DATE January 31, 2024

Project No. 21482114

**RESPONSE TO GEOTECHNICAL PEER REVIEW COMMENTS FROM GEMTEC
PROPOSED RESIDENTIAL DEVELOPMENT
3930 AND 3960 RIVERSIDE DRIVE, OTTAWA, ONTARIO**

Title: Cross Section A-A  
 File Name: 21482114\_Section A-A\_1m higher\_MG.gsz  
 Name: Static Drained  
 Method: Morgenstern-Price  
 Horz Seismic Coef.: 0

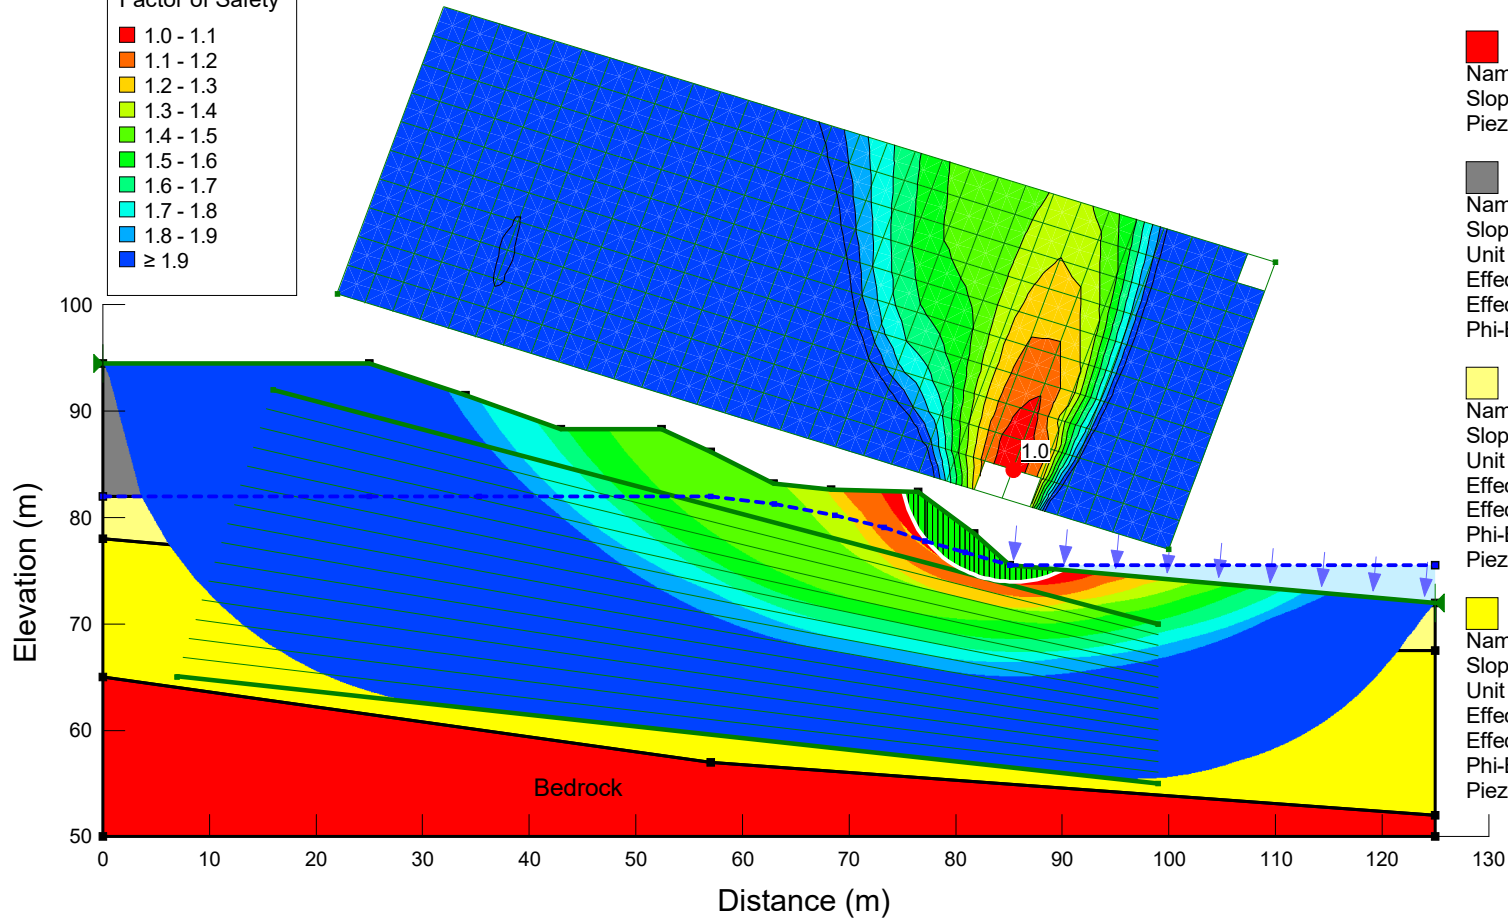
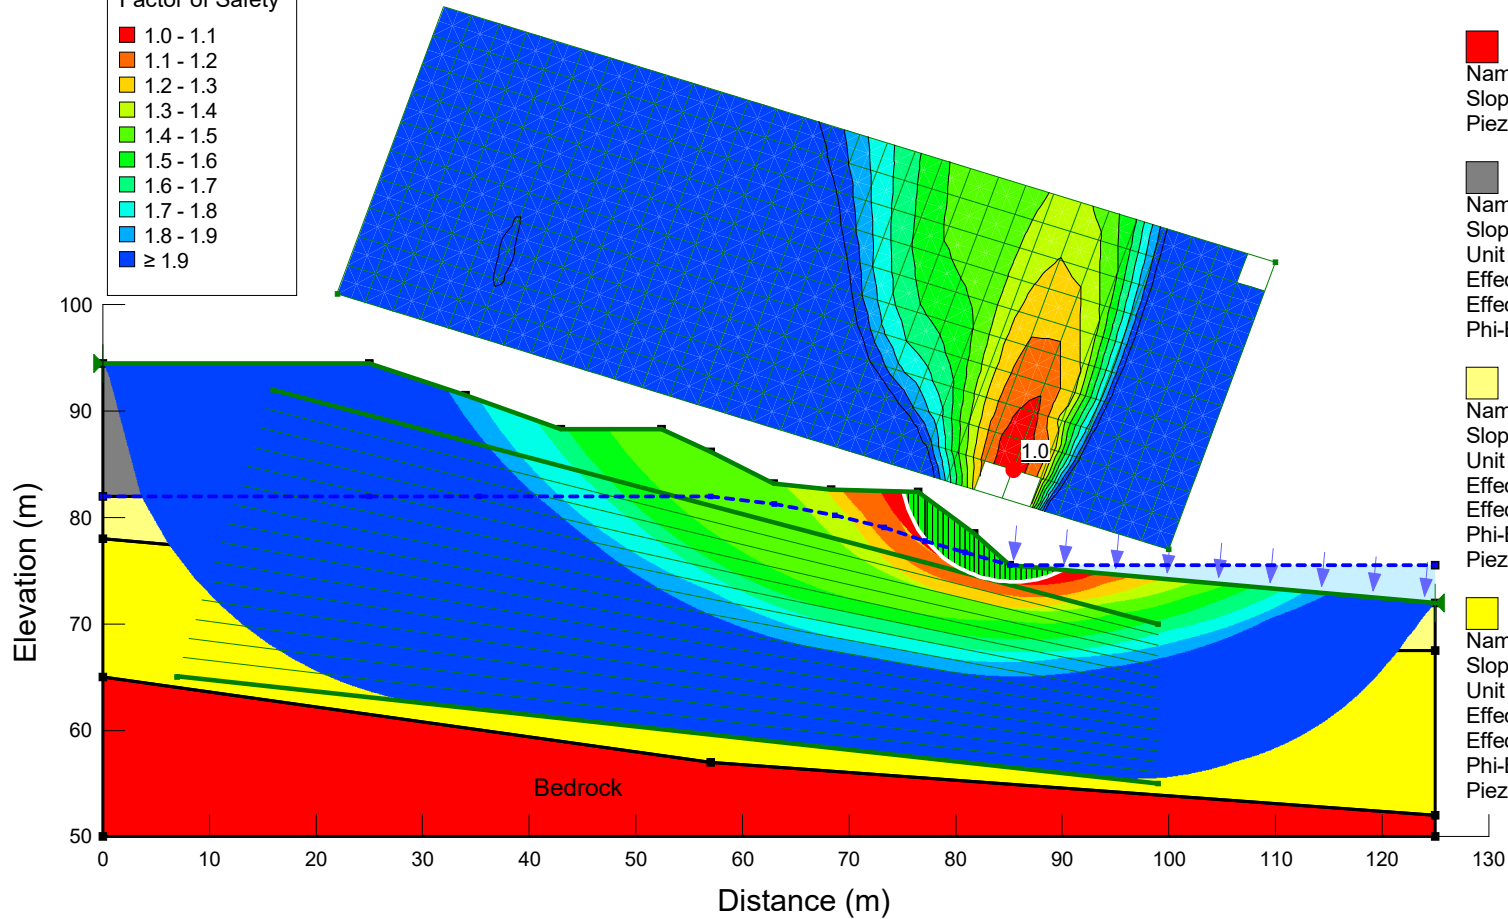
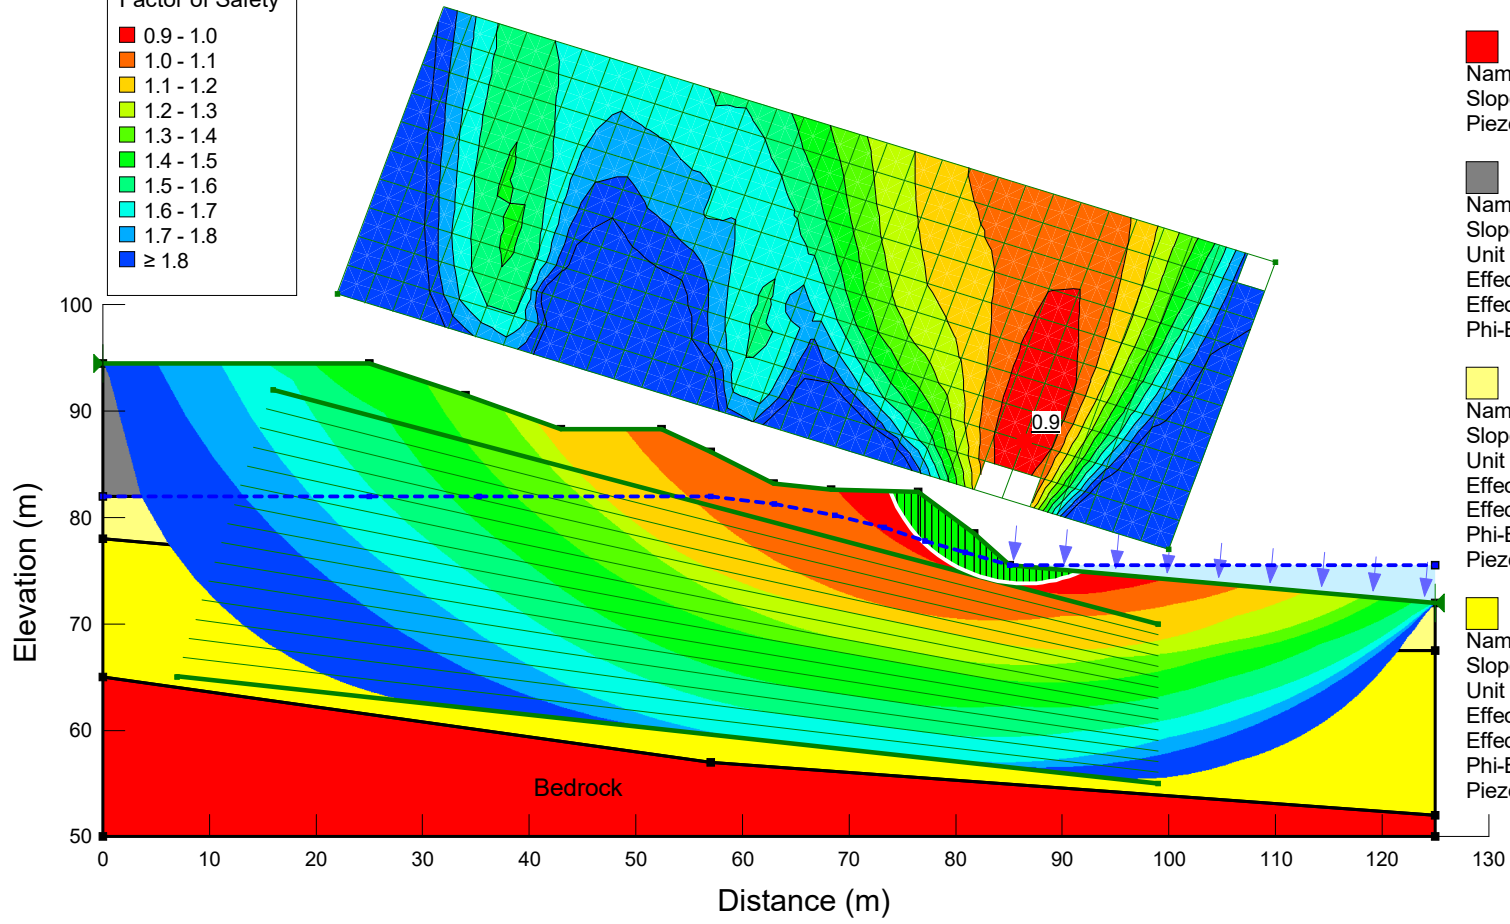
- 4) “The following comments are provided for the slope stability analysis carried out for Sections A-A', B-B', C-C', and D-D'. The safety map for the static and seismic analyses for the values of less than 1.5 and 1.1 respectively, extends past the upper edge of the point grid (for the slip circle centre), which may indicate there are slip circles with those factors of safety or less that extend horizontally farther than currently shown. This could potentially result in an increased stable slope allowance, and it is suggested that the model geometry be revised (by extending the point grid) to check the limits.”

- 5) “The groundwater level assumed in the static analyses for the South Area is at the base of the existing fill (i.e., at elevations of about 82 to 83 m) and is indicated to be based on the water levels measured in the various monitoring wells at the site. This would be Case 3 as outlined in the slope stability guidelines and may not be a realistic assumption. The fill materials above the native sands are not uniform in composition and contain cohesive layers and materials with high silt and clay contents that will tend to retain water and therefore it may not be reasonably conservative to assume the fill materials are fully drained as assumed in the slope stability analyses. The water levels summary in Section 4.1 of the report notes that: “In the South Area, the groundwater level was generally found to be between 12 to 16 m depth (i.e., between elevations of about 75 to 83 m), but as shallow as about 6 m (i.e., elevation of about 88 m).”

Response – *The models for the sections identified above were revised (by extending the point grid), no differences have been observed in the stable slope allowance.*

Response – *While the water level in the south area was recorded to be between elevations of 75.1 and 87.6 m (in monitoring wells as well as from CPT Dissipation testing), it was generally found to be below elevation of 79 m. Only one single borehole location had a higher water level of 87.6. We therefore feel that the original assumptions regarding groundwater level are reasonable assumptions for the overall groundwater depth in the area of interest. Nonetheless, as a precautionary measure and an additional check, the slope stability models for these four sections were revised to take into account for the possibility of a higher groundwater level in South Area by adjusting the piezometric line in the analysis upward in the east side of the site (where the single high level was recorded). This adjustment results in a very minor change to the slope stability (well within the margin of error of the data and assumptions which go into the analysis). The change is of sufficiently small magnitude as to make no meaningful difference to recommended stable slope allowance, and therefore we feel that the originally recommended setbacks may be maintained. The results of the revised slope stability analysis are attached to this memorandum.*
